# TRANSPORT AND ACCESSIBILITY IMPACT ASSESSMENT

**TAFE NSW Construction Centre of Excellence  
Nepean Kingswood Campus – 2-44 O’Connell Street, Kingswood**

Reference: 20.456r02v08  
Date: May 2021

Swept Path Analysis

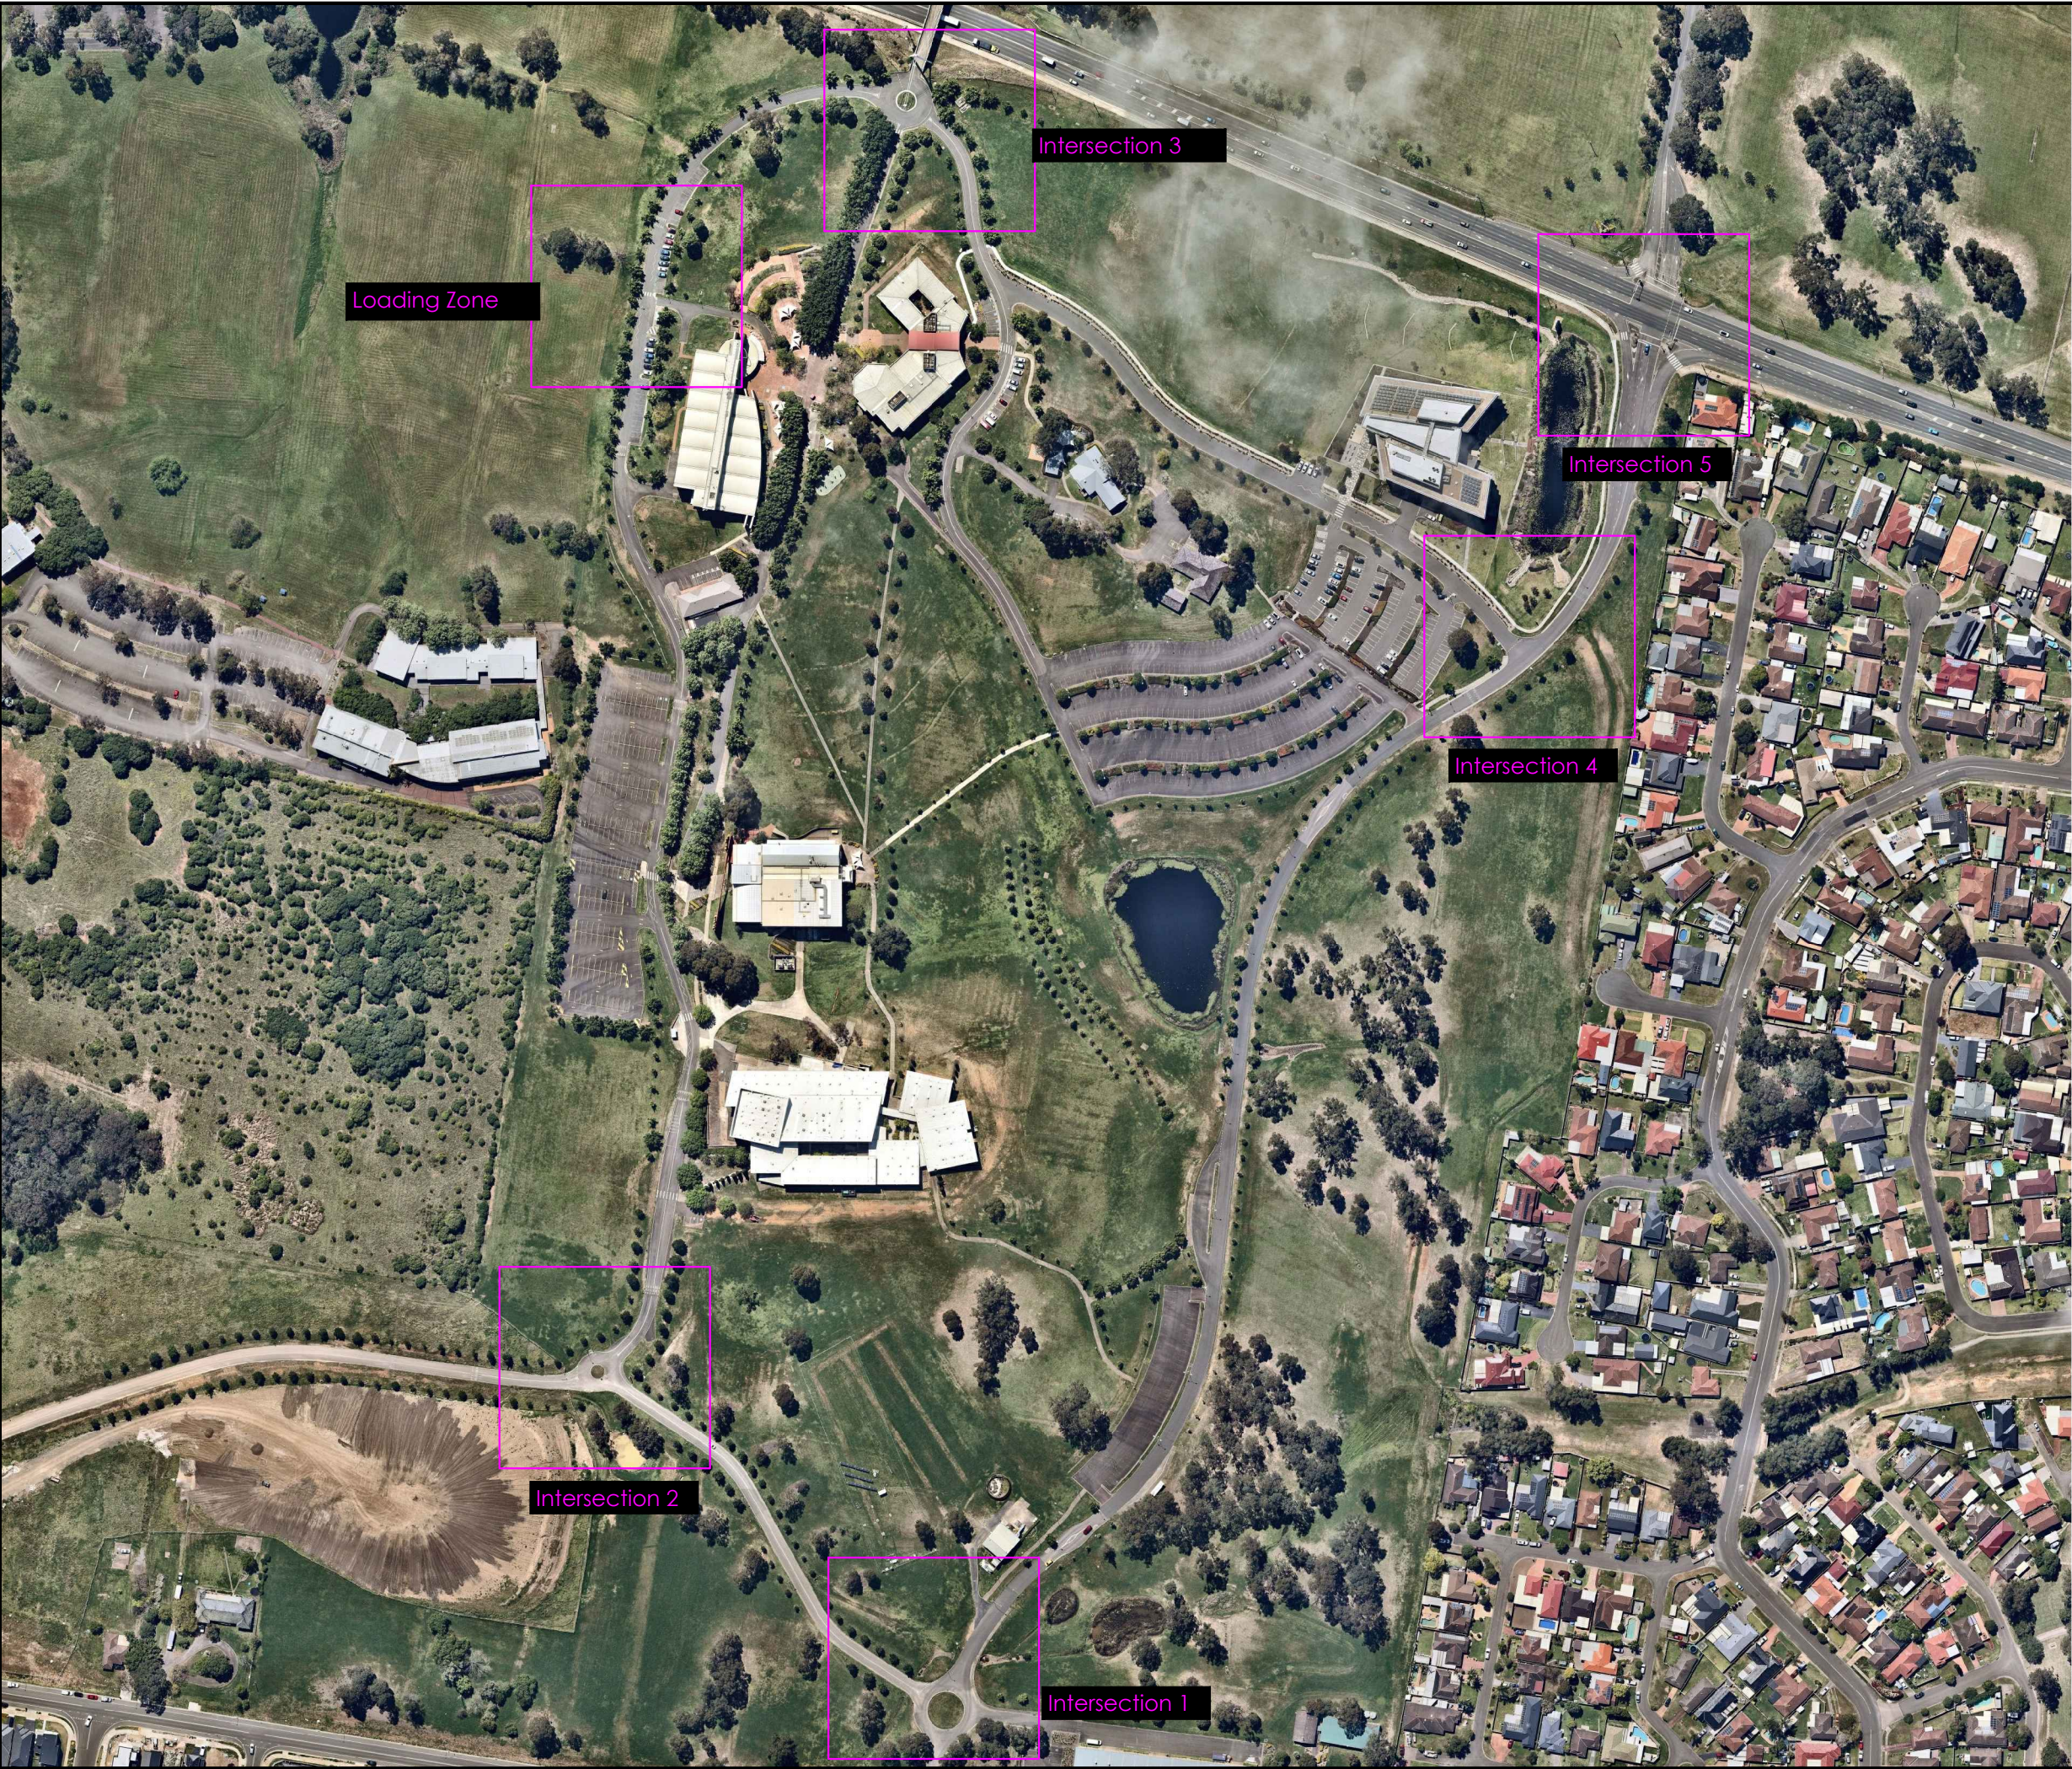
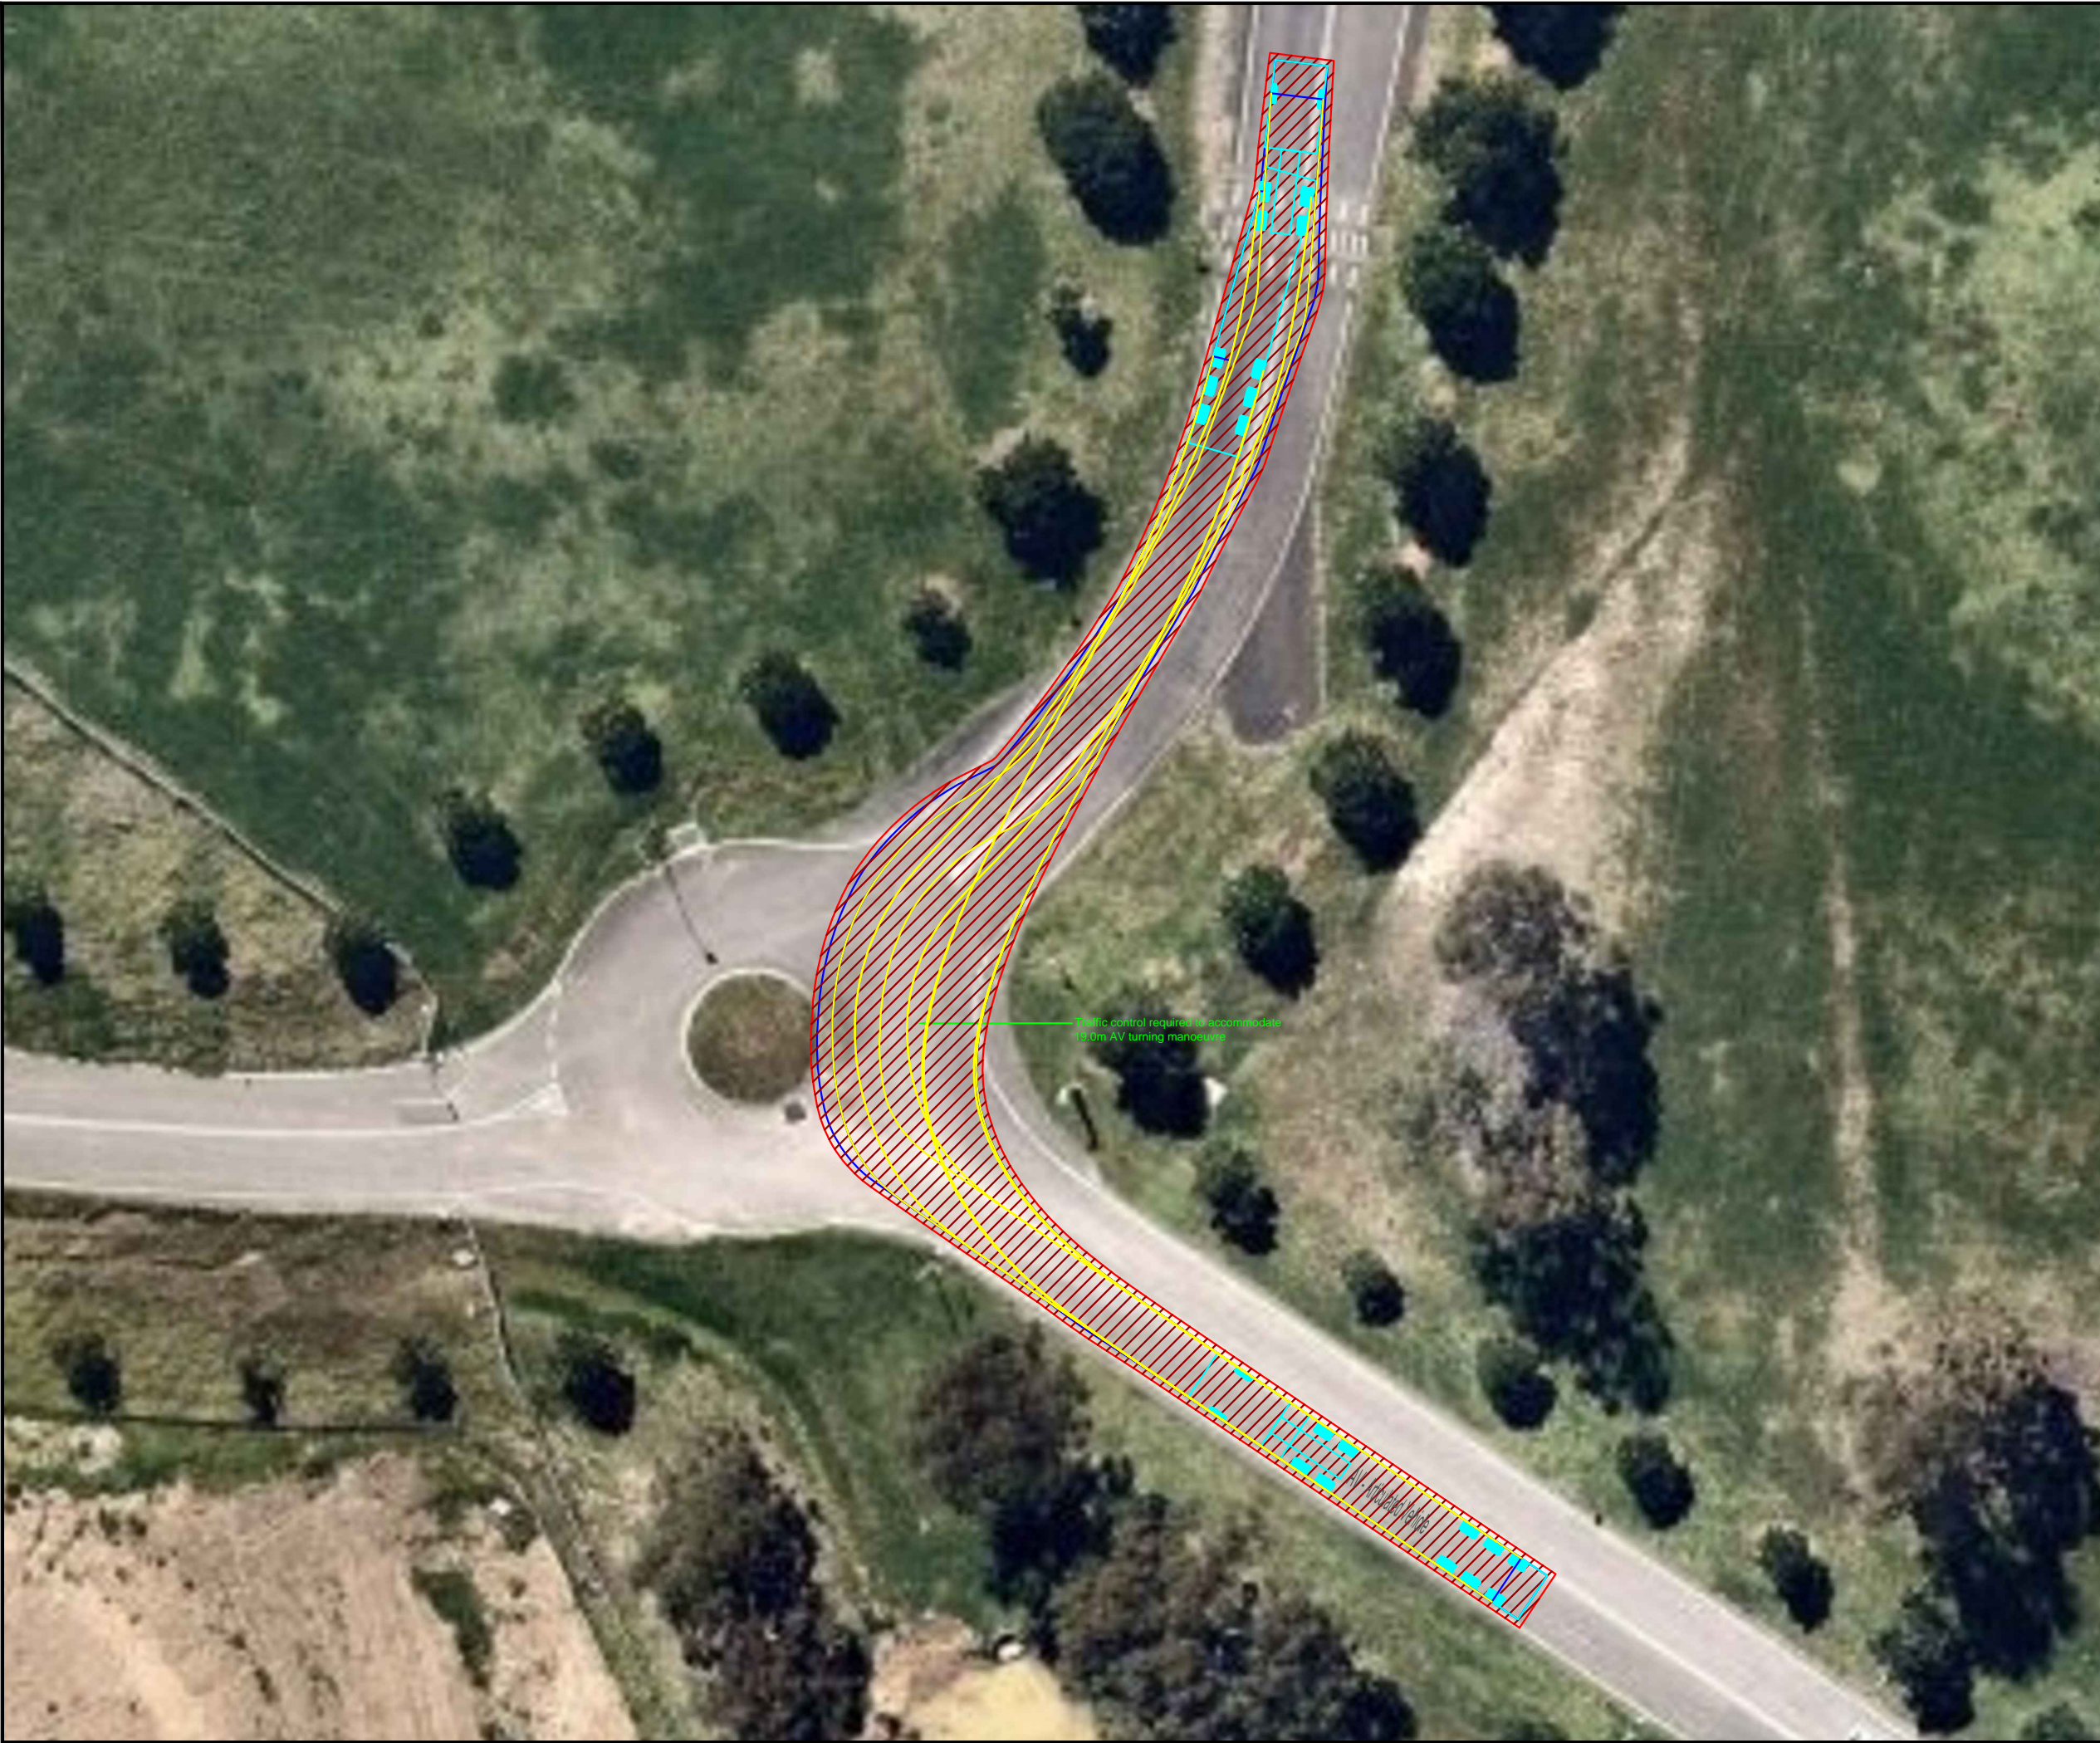
*b. Appendix C Loading Zone Swept Paths: Traffic Controller is recommended to ensure there is no conflict between construction trucks and vehicles / pedestrians using the carpark.*

**TRAFFIX Response:** Appendix C Loading Zone swept path has been updated to include a traffic controller. It is noted that this is a Preliminary CTPMP and further details of traffic controllers will be provided within the detailed CTPMP and final TCPs.
